<b>Application Ref:</b>	3/2021/0215	 Ribble Valley Borough Council <a href="http://www.ribblevalley.gov.uk">www.ribblevalley.gov.uk</a>
<b>Date Inspected:</b>	30/03/2021	
<b>Officer:</b>	AB	
<b>DELEGATED ITEM FILE REPORT:</b>		<b>REFUSED</b>

<b>Development Description:</b>	<b>Proposed extension of existing campsite to provide additional 10 caravan pitches, 4 camping glamping pods. Erection of a proposed toilet and welfare facilities building and associated landscaping works.</b>
<b>Site Address/Location:</b>	<b>Marl Barn Wigglesworth Road Slaidburn Lancashire BD23 4SX</b>

Drawing Title
Existing Shower and Toilet Facilities Elevations and Replacement Proposed Toilet and Welfare facilities Building Floor Plan and Elevations

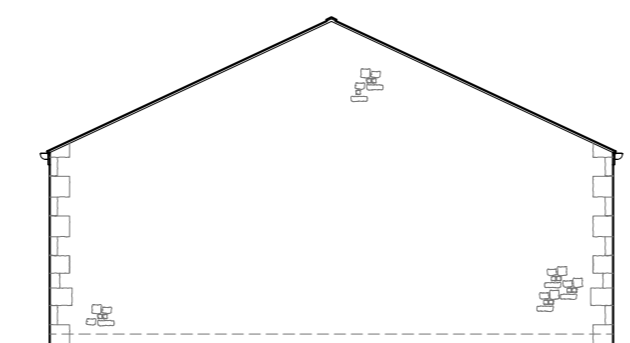
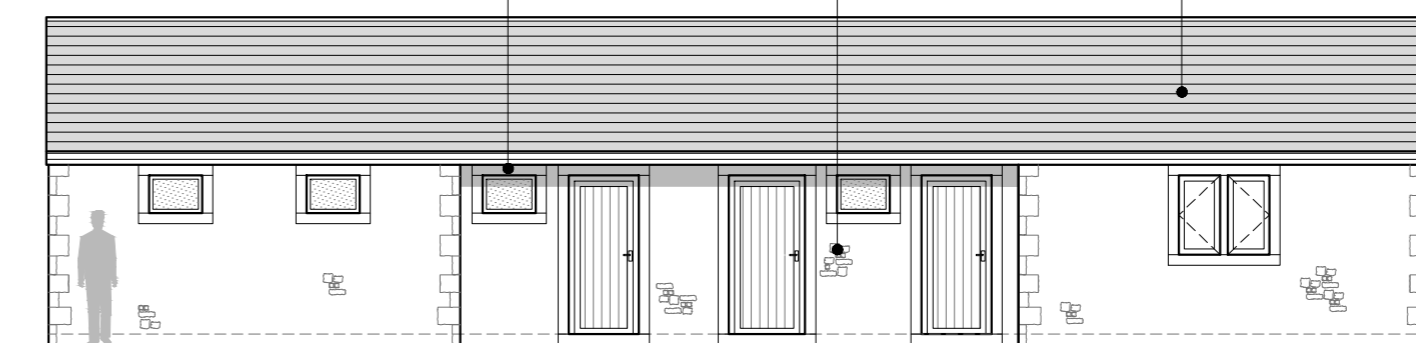
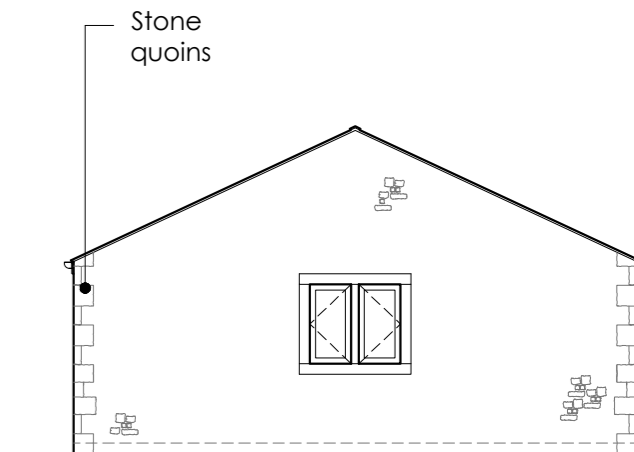
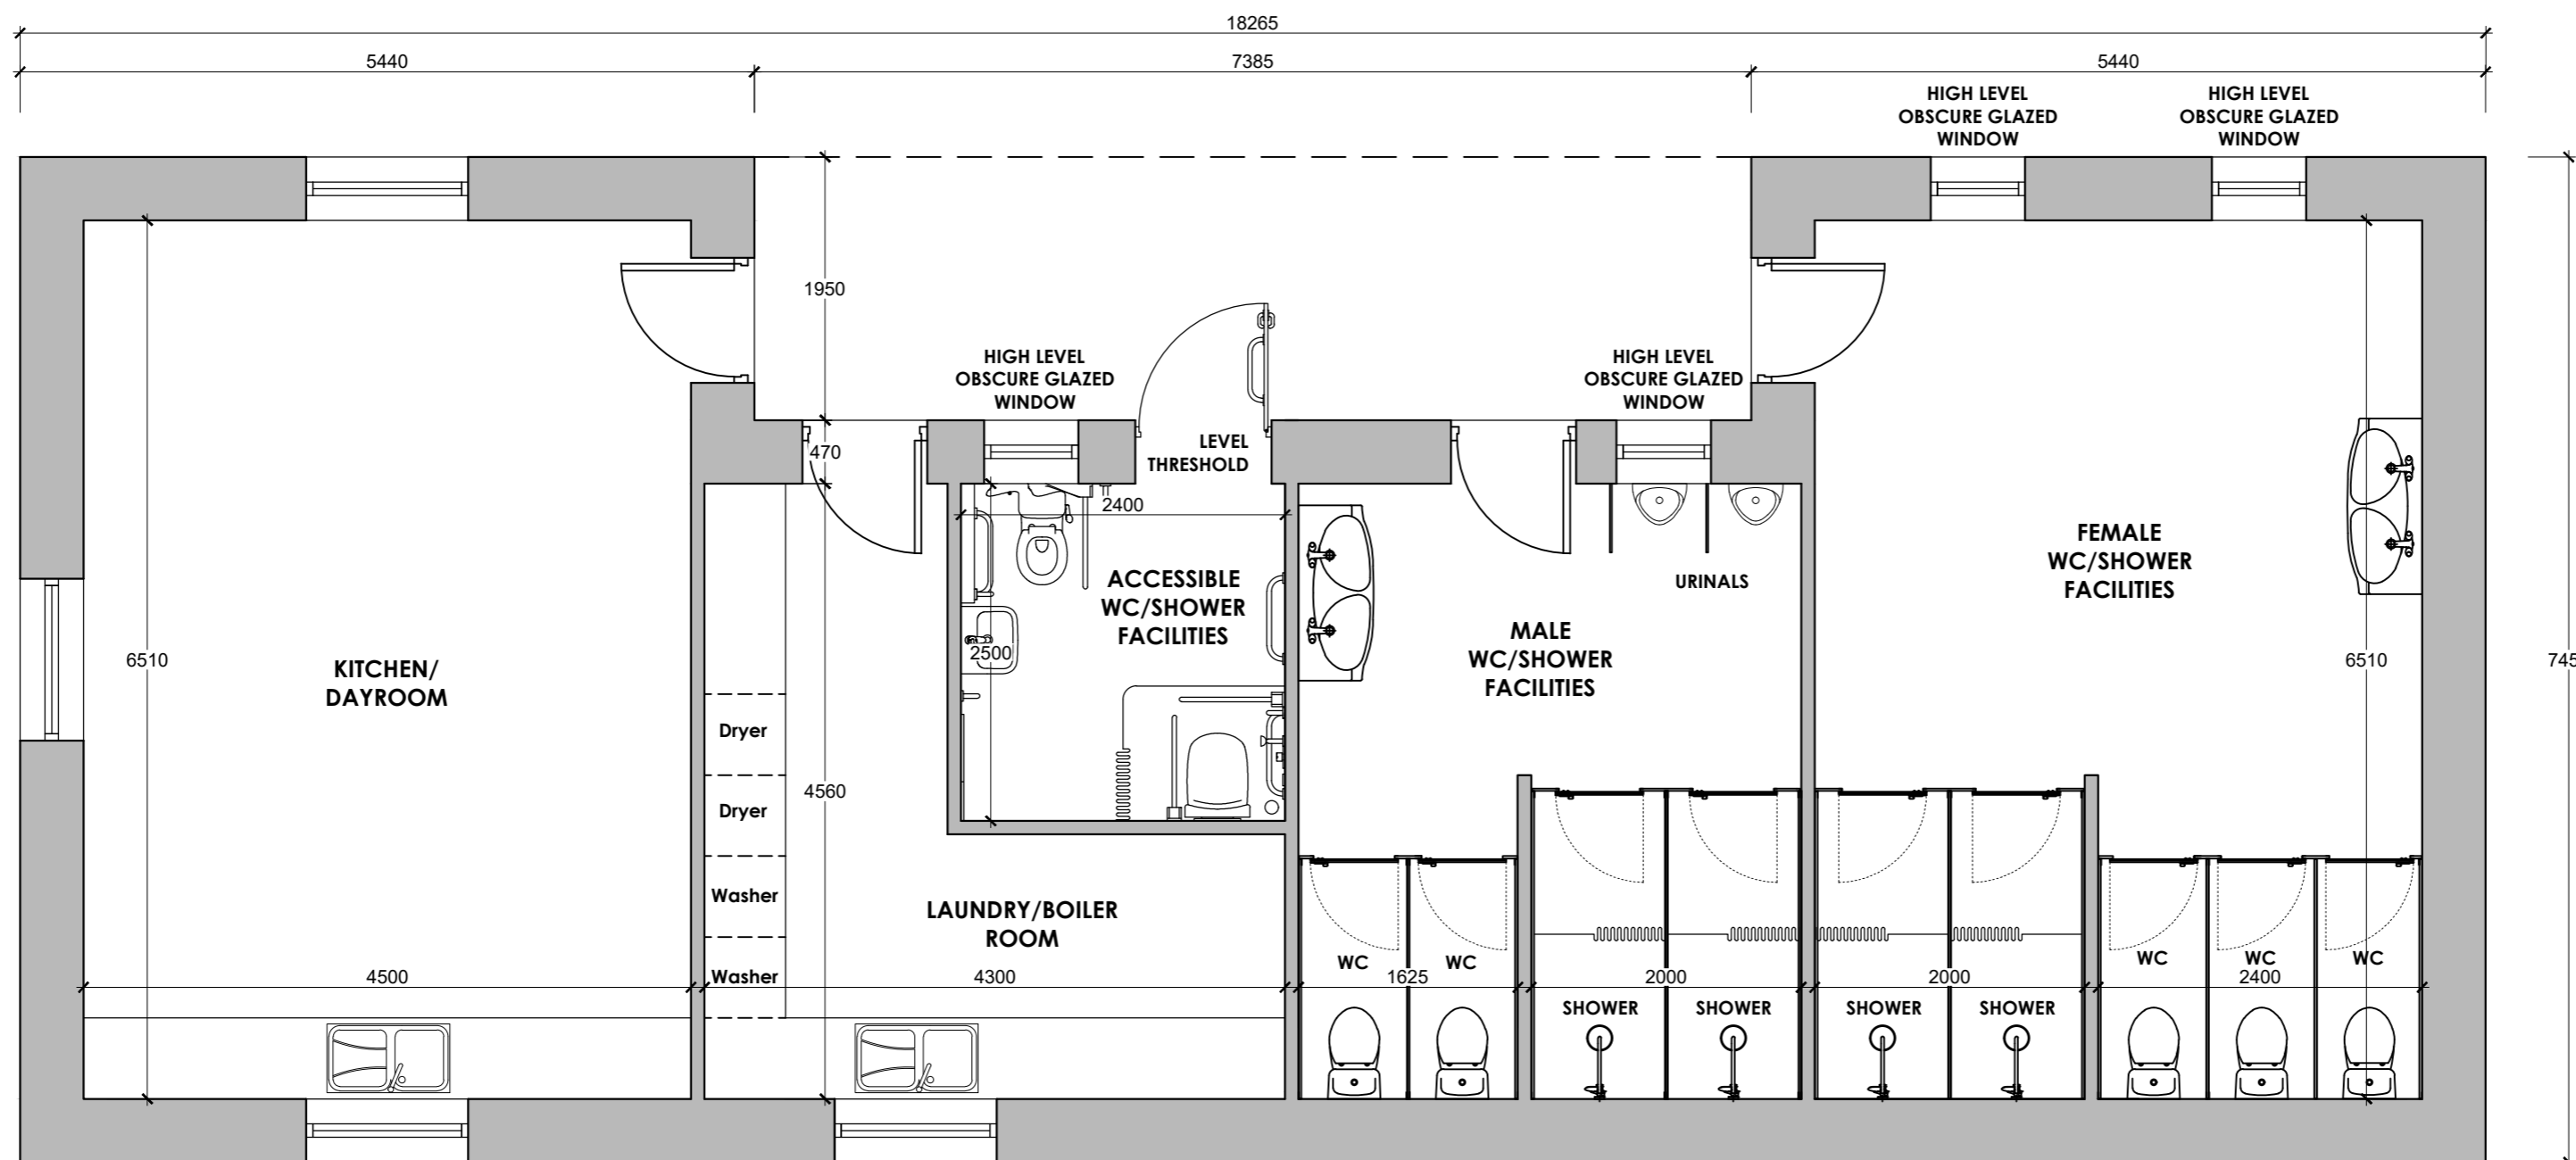
The new toilet and shower facility building would be located to the south of the existing site and would be constructed from natural stone with stone window and door surrounds and a blue slate roof. It would measure 18m x 7.5m and would have a height of 4.4 metres.

The erection of the proposed toilet and welfare building to the south of the existing site would be constructed using natural materials in keeping with the area and its height of 4.4m would mean that it would not be prominent addition. Importantly, its location south of the existing caravan and campsite, between the caravan and campsite and the holiday let and agricultural buildings to the north, would mean it would be screened by existing development and would be seen as part an established group of buildings.
